Our Ref: AWE200083-L01: BCP/bcp
Contact: Dr Brett C. Phillips

22nd February 2021

RESPONSES TO FLOODING SUBMISSIONS, ASPECT INDUSTRIAL ESTATE, KEMPS CREEK, NSW

Figure 26 200 yr ARI Flood Extents and Flood Levels - Stage 1 Conditions

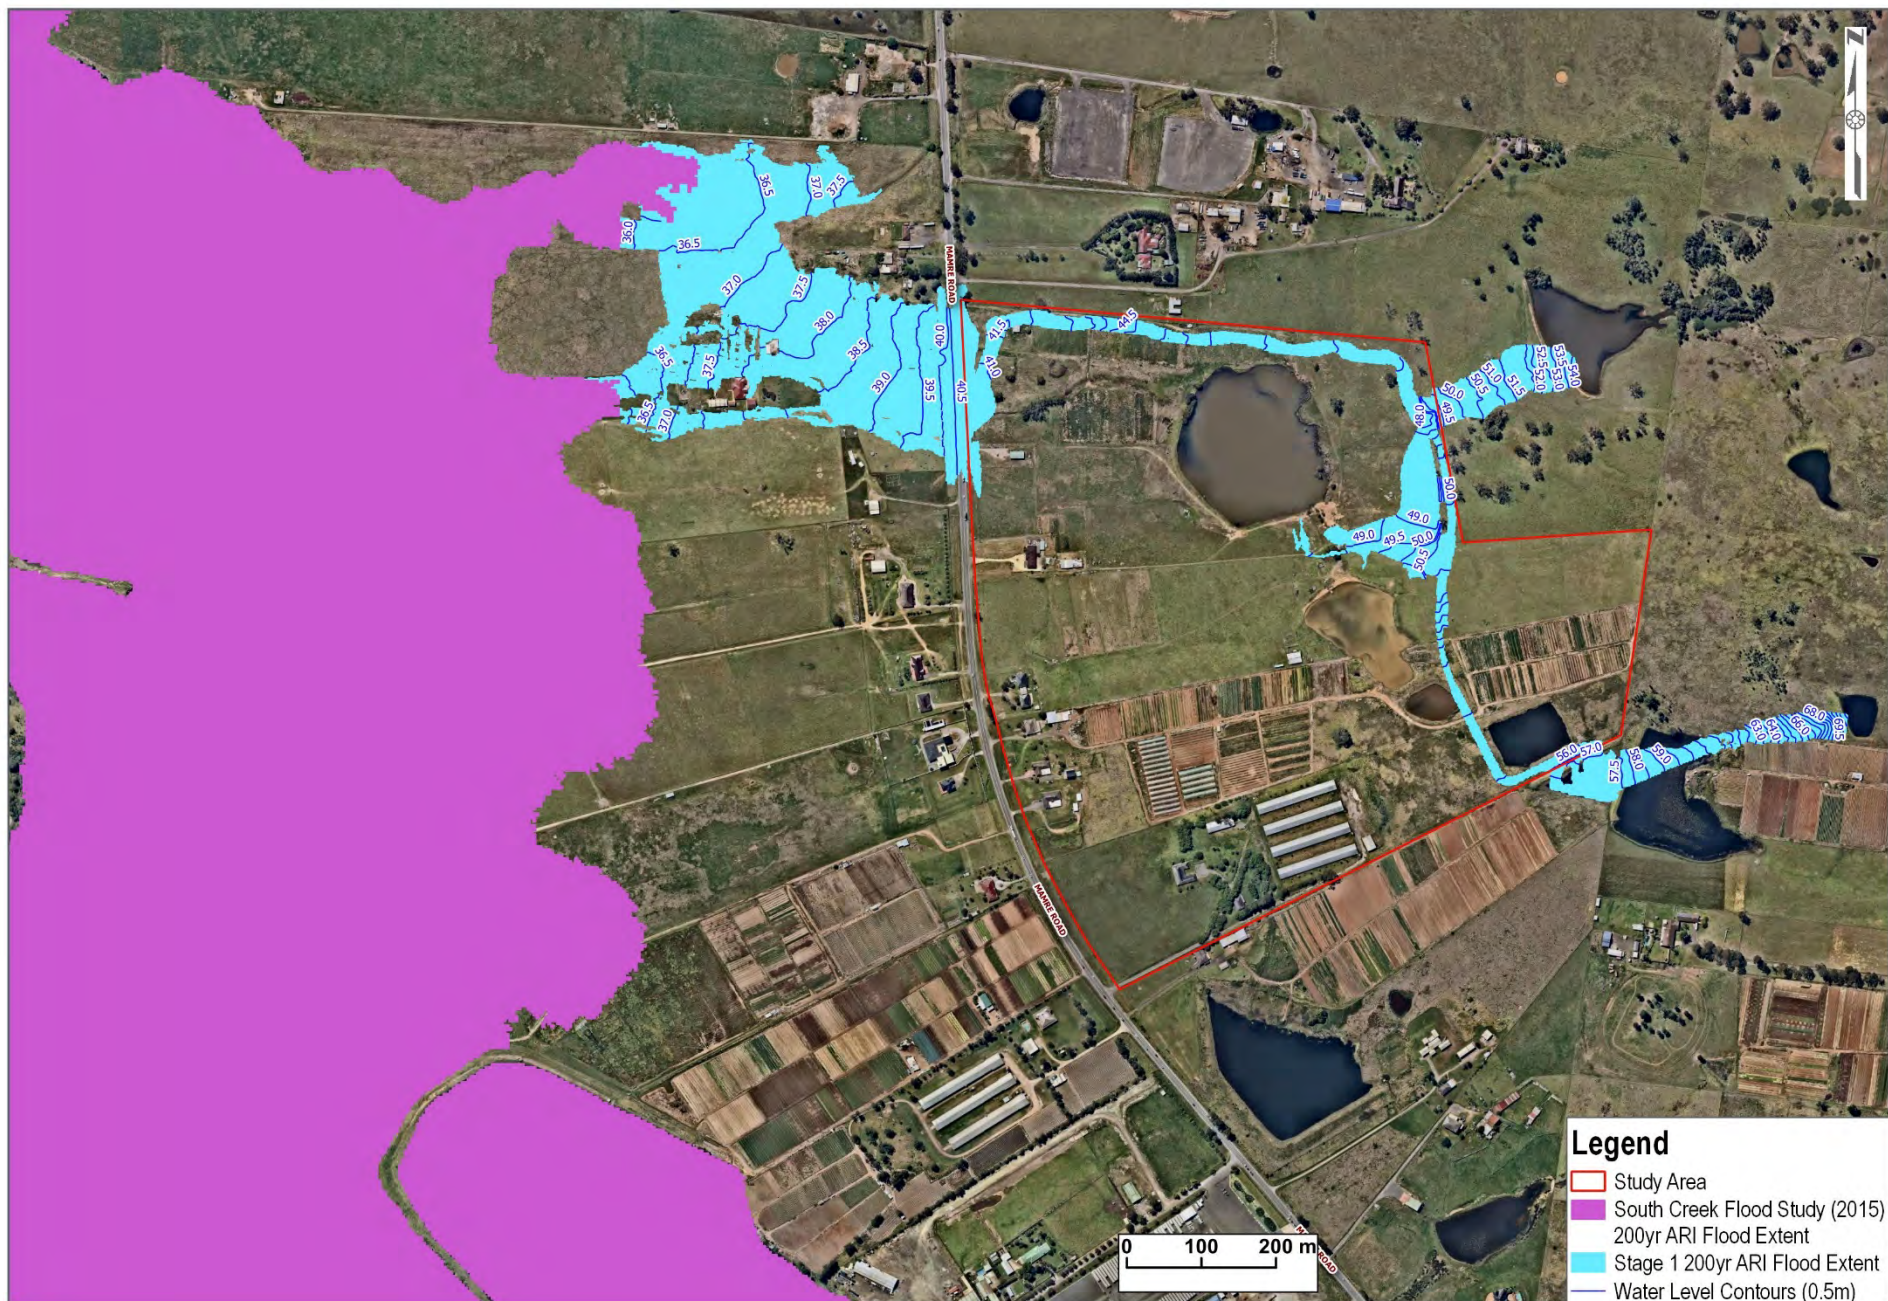
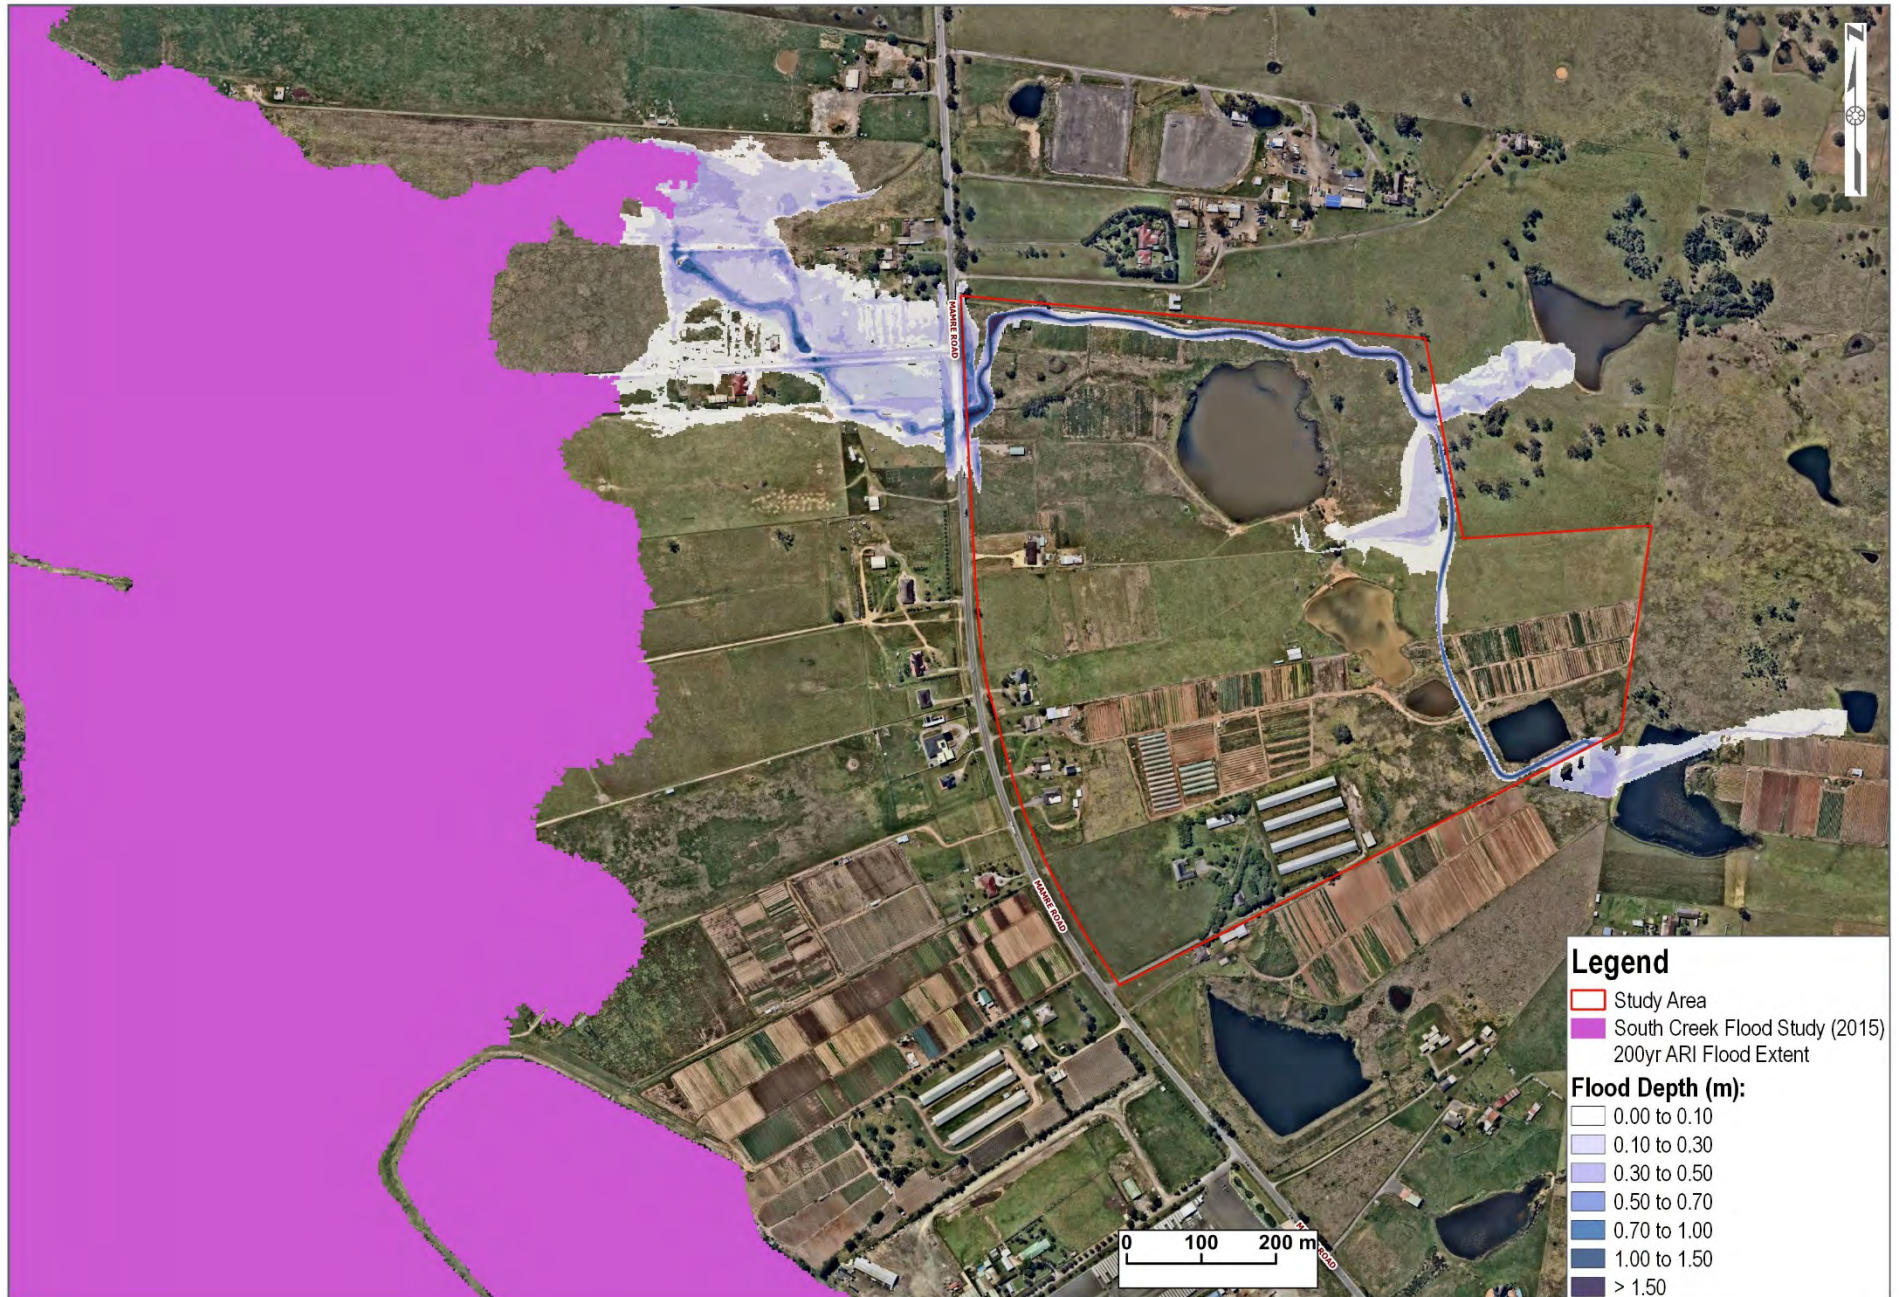
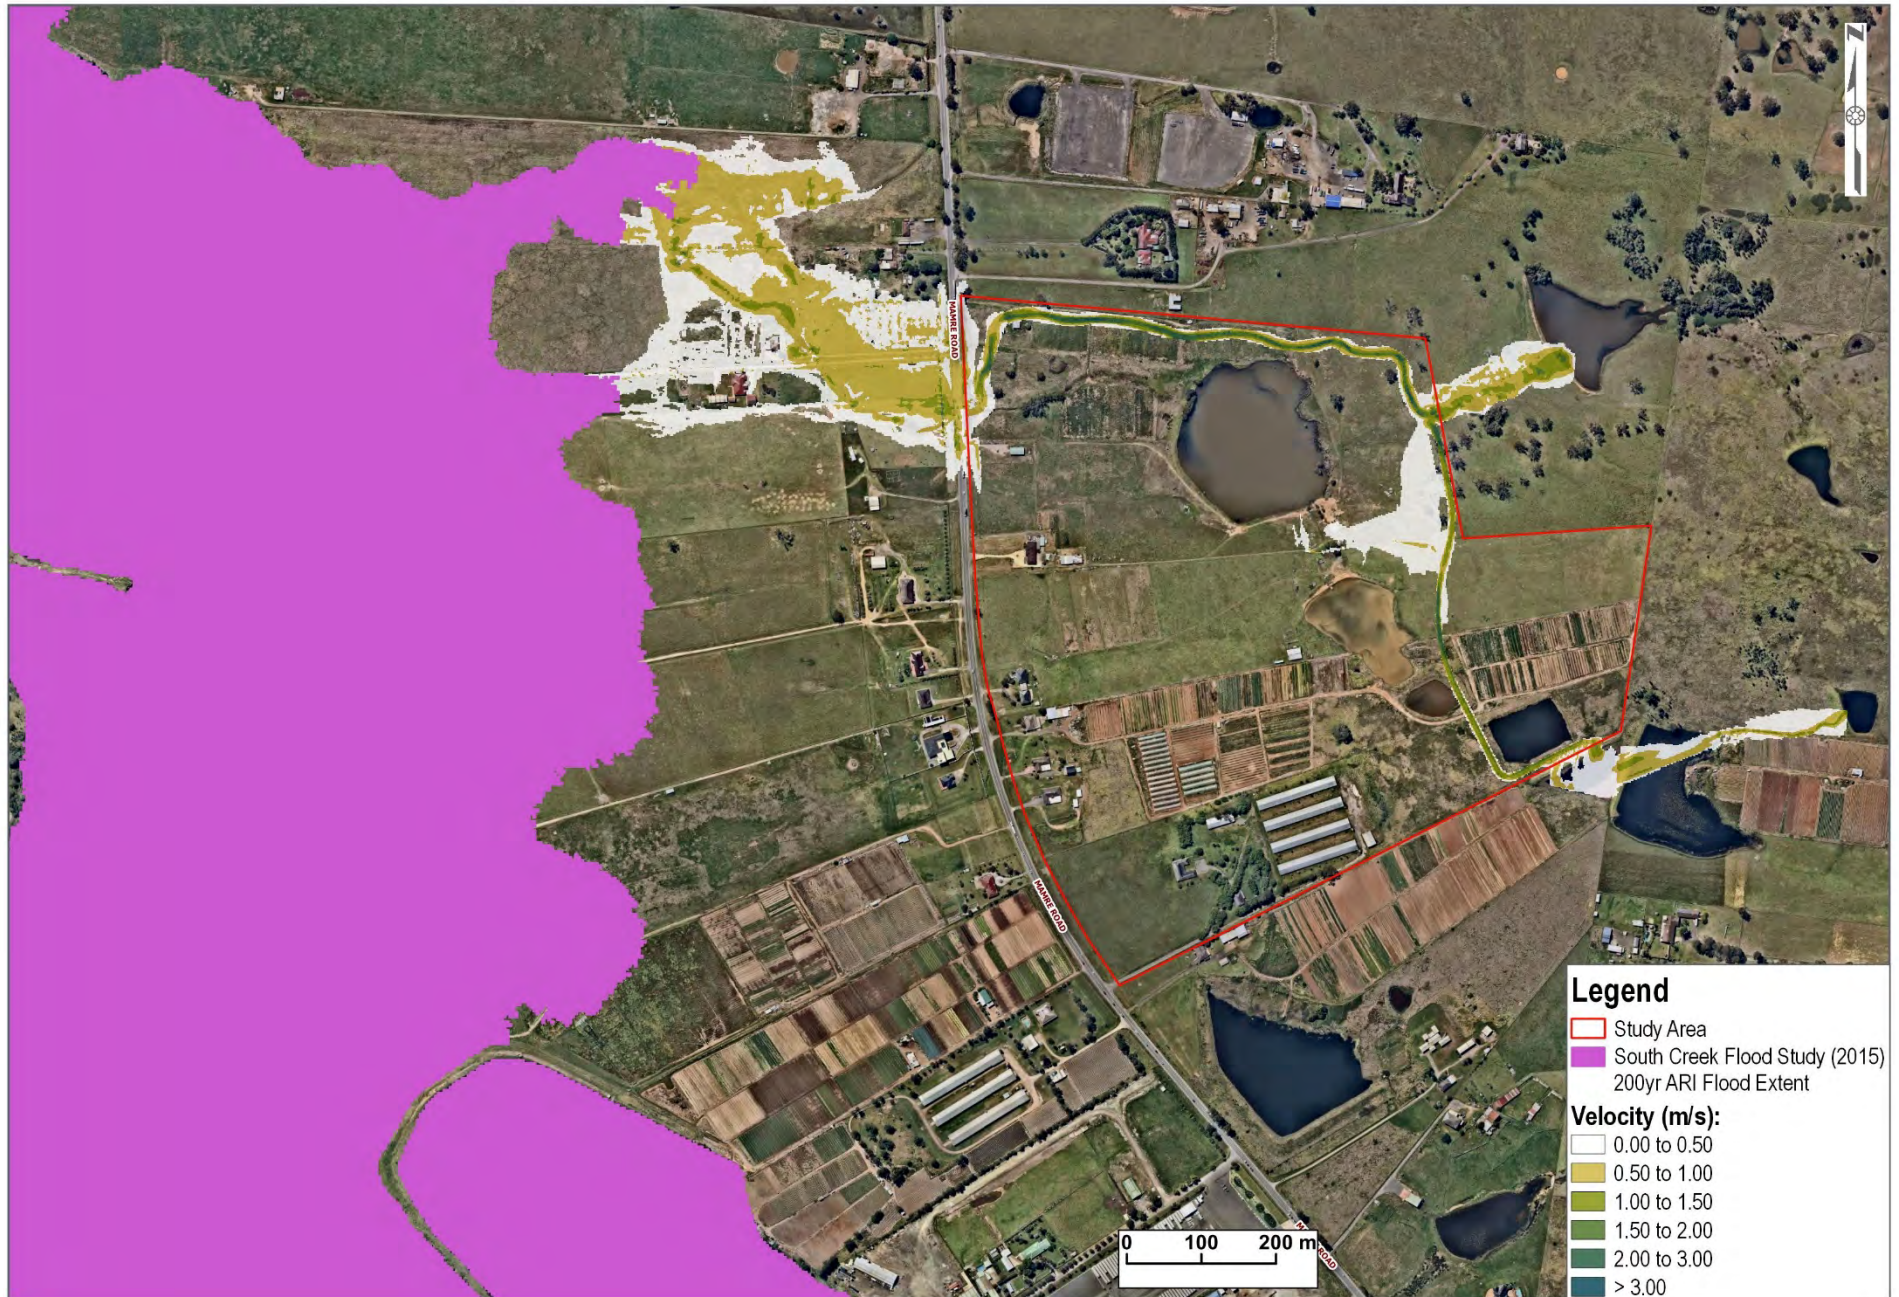
- *The developed scenario maps present local overland flow for Stage 1 which comprises of two industrial lots on the northern part of the site. However, from a flow management perspective, an overland flow study should consider the ultimate developed scenario of the site instead of considering each progressive development independently.*

- *All maps for developed conditions should properly depict the layout of the development, locations of proposed constructed channels and the location of the proposed detention basin.*

The final masterplan has been assessed and the results of the assessment have been incorporated into an updated version of the FIA report.

The updated Figures have been incorporated into an updated version of the FIA report.
